Ribble Valley Borough Council  
Housing & Development Control

Application no: **3/2023/1026**

Address: **23 Pendleton Road Wiswell BB7 9DD**

Proposal: **Proposed demolition of garage and construction of two-storey extension to side and rear and single storey extension to rear. Alterations to existing window and door openings and creation of new parking area.**

A2.3.

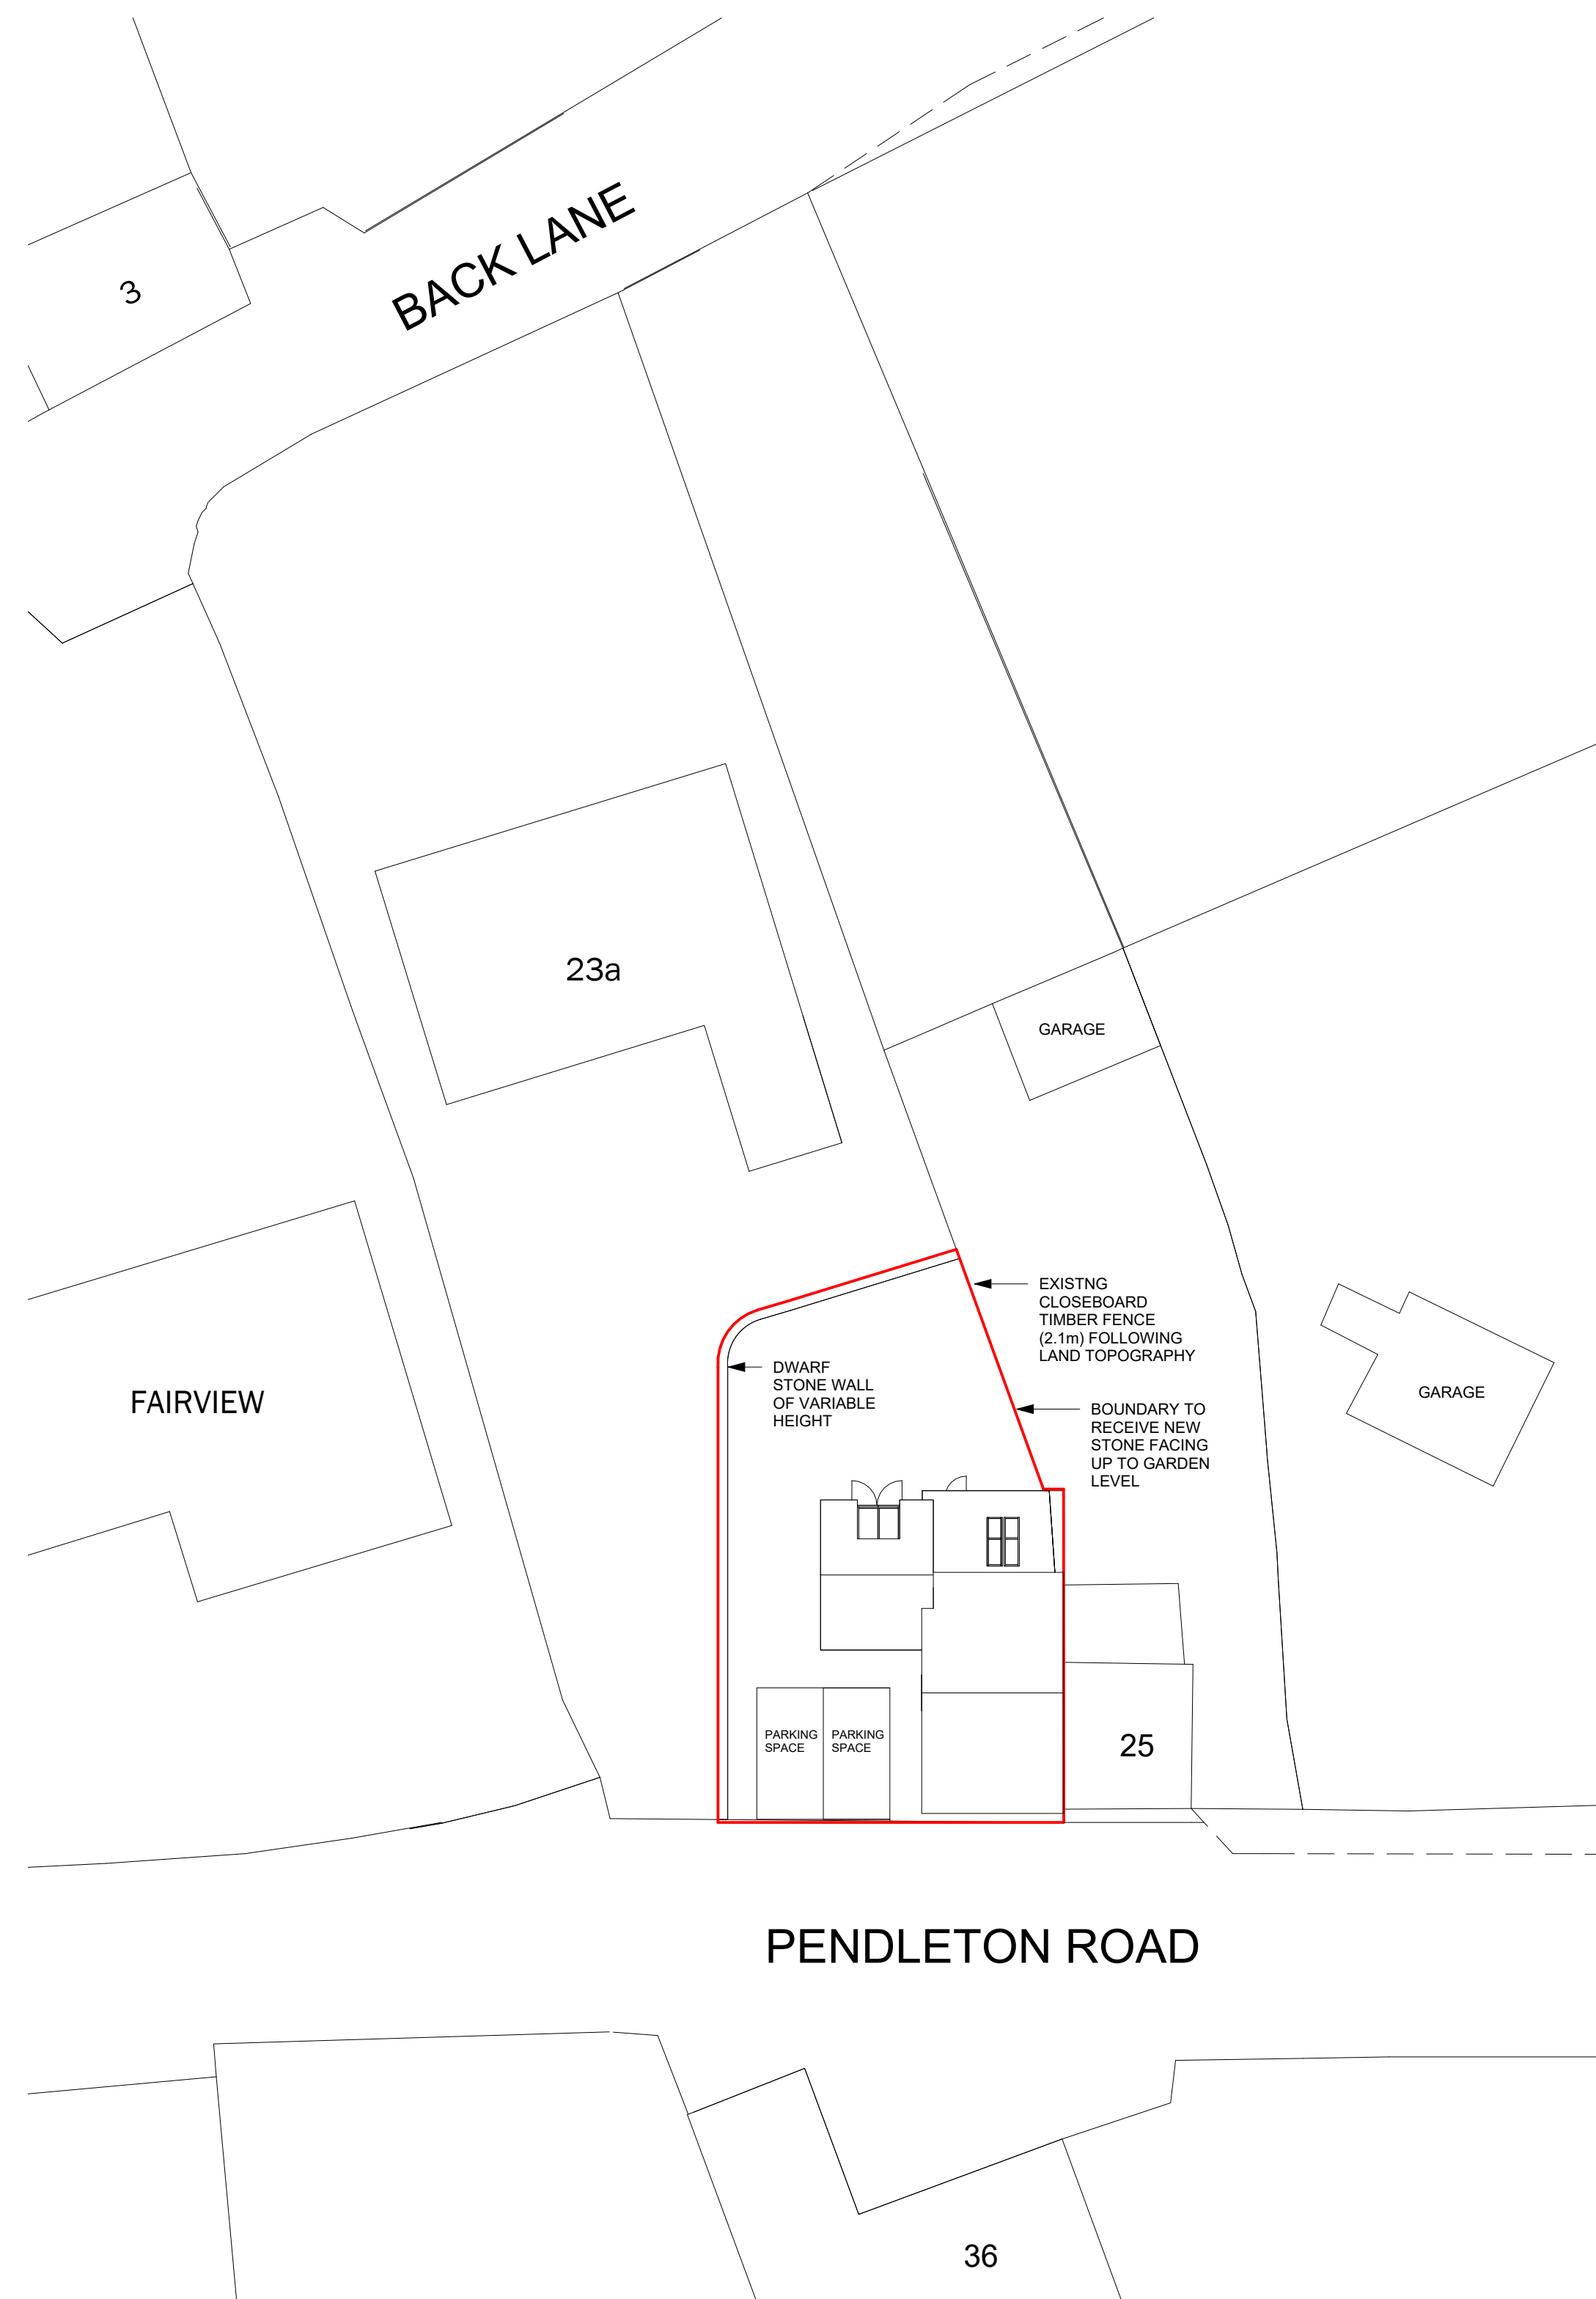
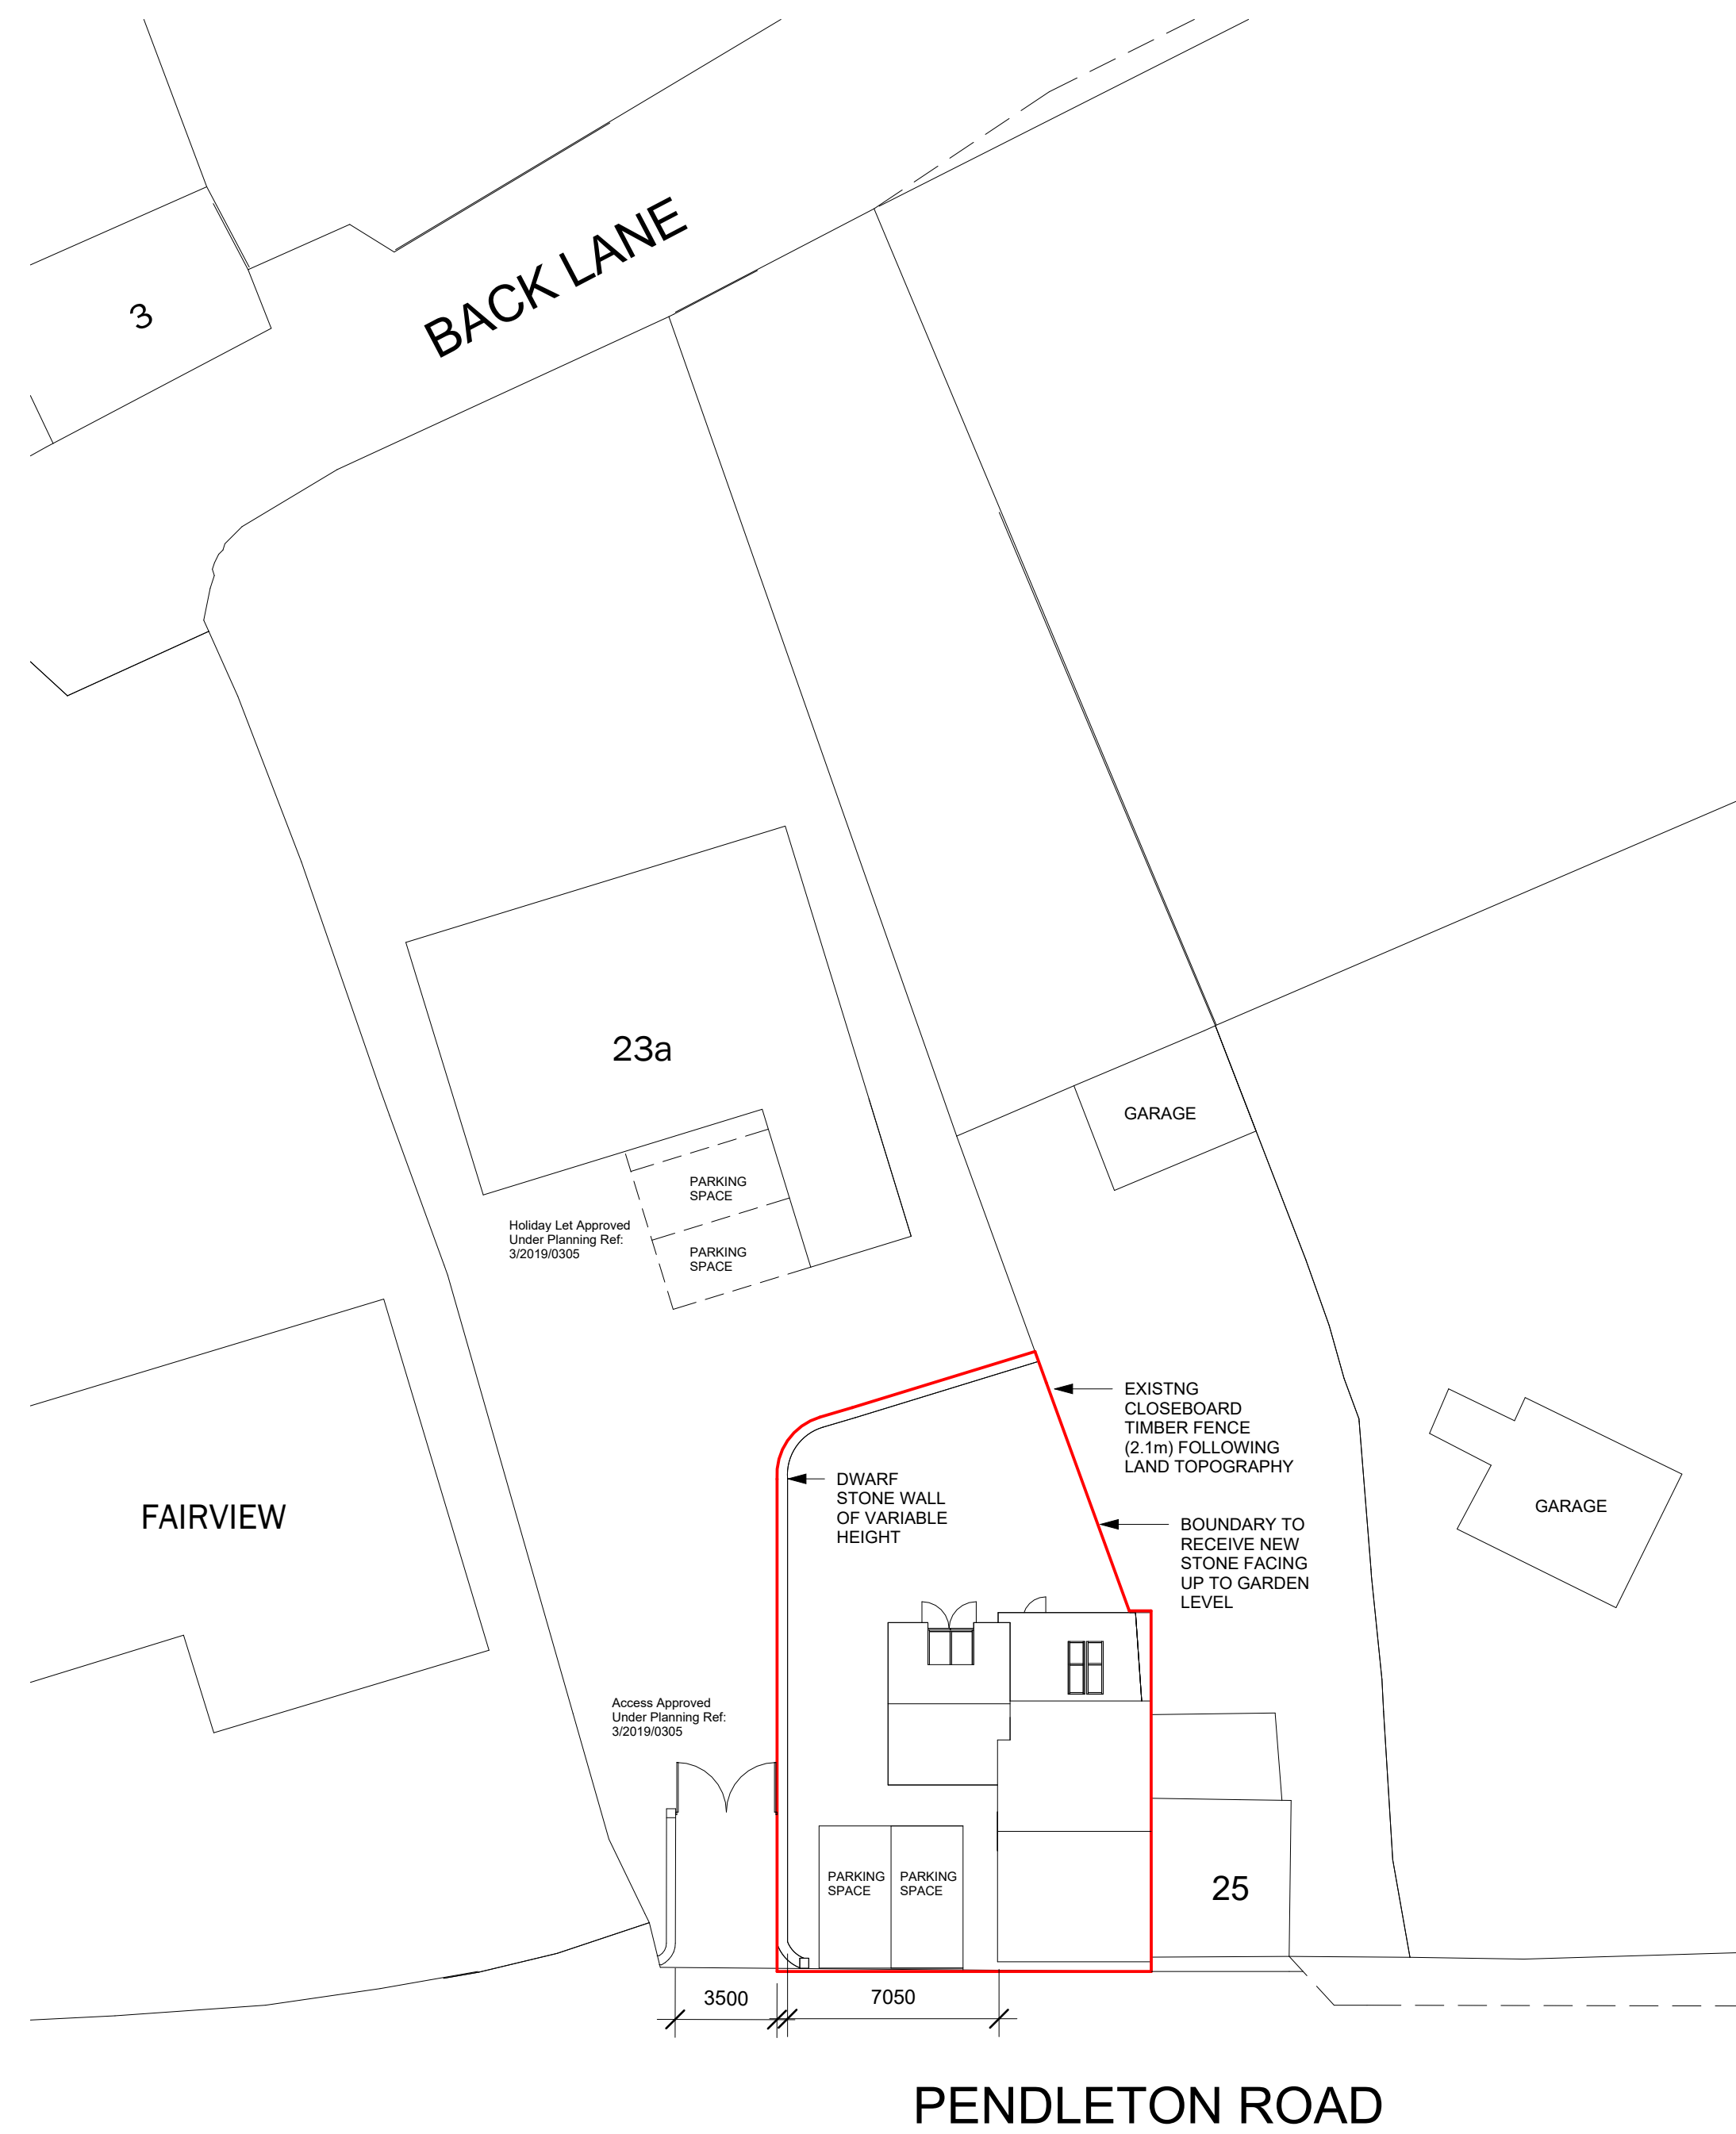
The LHA have reviewed Peter Hitchen drawing number A2.3 titled "Existing and Proposed Site Plan" and are concerned that the proposed parking area will conflict with the access which will serve the holiday cottage located to the rear of the site. The holiday cottage and the access was approved under application reference 3/2019/0305 where the site was also planned to be accessed from. Therefore, to ensure that the proposed parking area does not conflict with the already approved access and the spacing between each access is safe and suitable, the LHA require a scaled drawing to be submitted showing both accesses.

The LHA require a revised site plan to be submitted showing the parking area for the proposed dwelling and the access which will serve the holiday cottage, approved under application 3/2019/0305, should the application be extant. This is because the LHA are concerned that the proposed parking area will conflict with the approved access. Therefore, further information is required.

The LHA advise that should the Applicant still own the land where the holiday cottage is located, that the dwelling utilises the approved access. This was the original idea when application references 3/2019/0305 and 3/2017/0889 were approved.
